**CITY OF MERCER ISLAND**

August 29, 2017

RE: ADU17-003, CAO17-005, SHL17-007, SUB17-004 Second Review Letter  
Land Use Applications for proposed home, ADU, driveway and retaining wall construction within  
a steep slope along the shoreline for the Lady Bug Trust. DEV17-009 Impervious Surface  
Deviation Application has been withdrawn.

3 ADU - west elevation
1/4" = 1'-0"

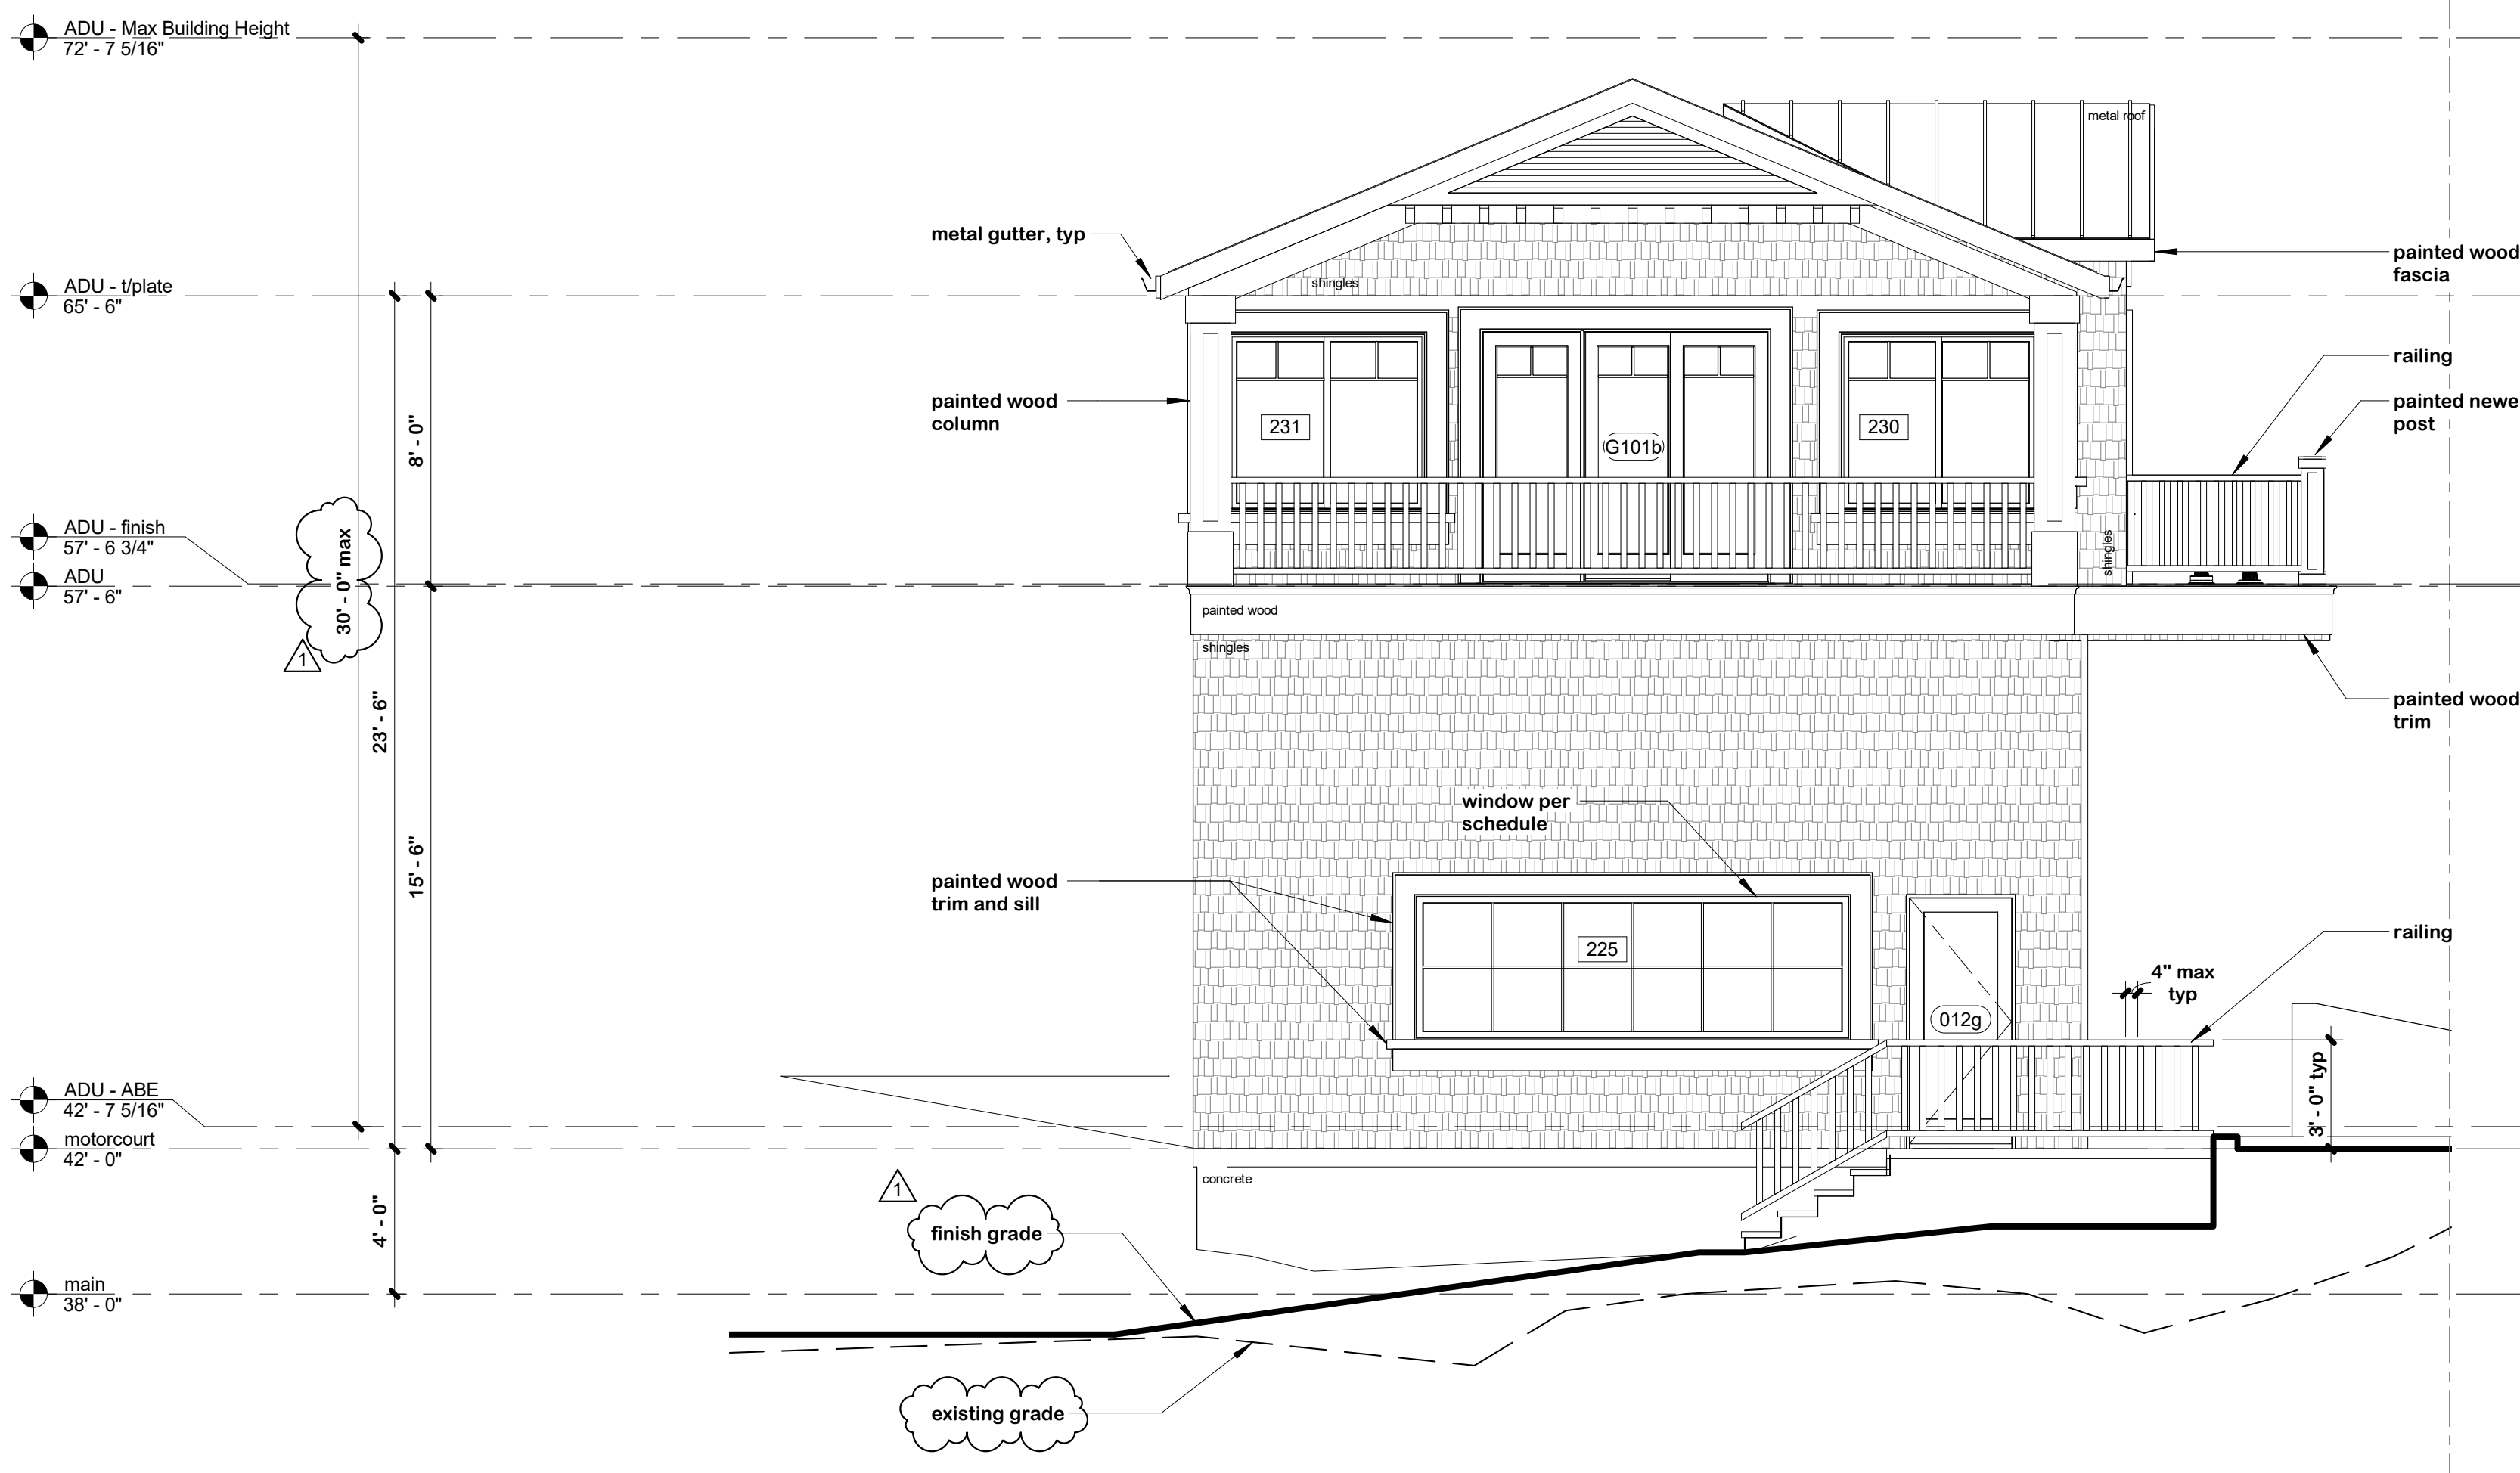
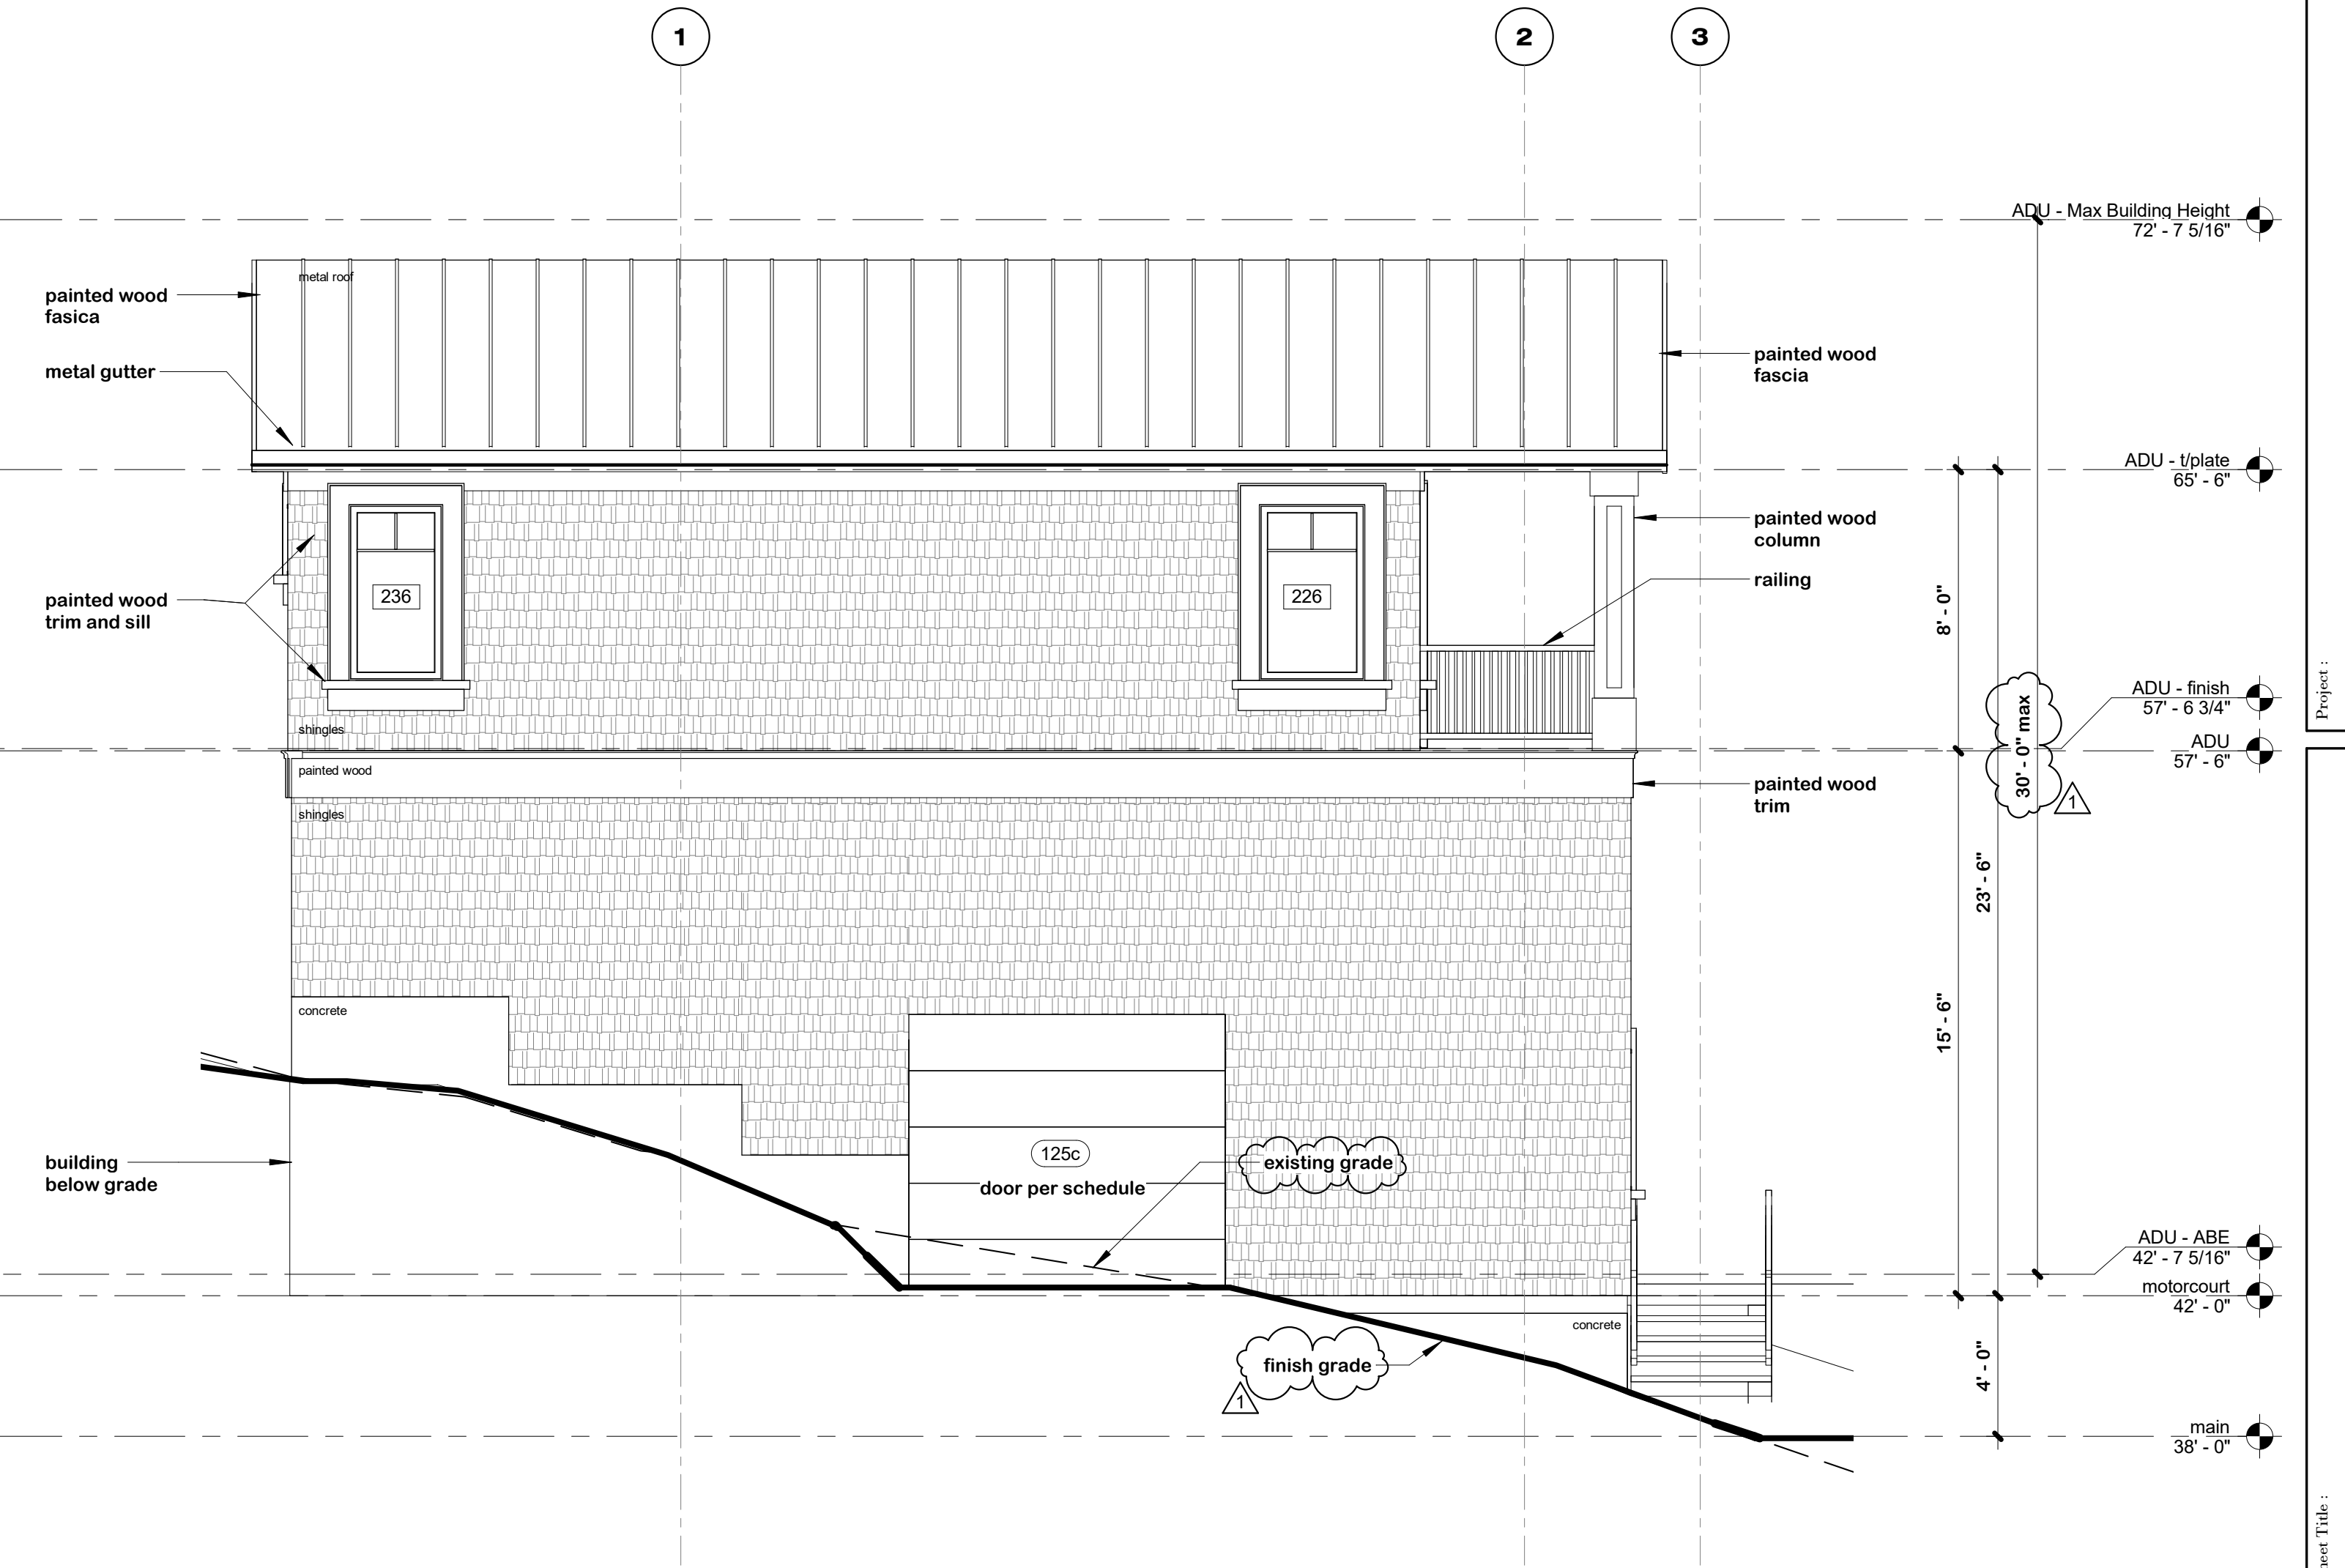
8. Please provide building elevation drawings that the ADU shall be designed consistent with the existing roof pitch, siding, and windows of the principal dwelling unit.
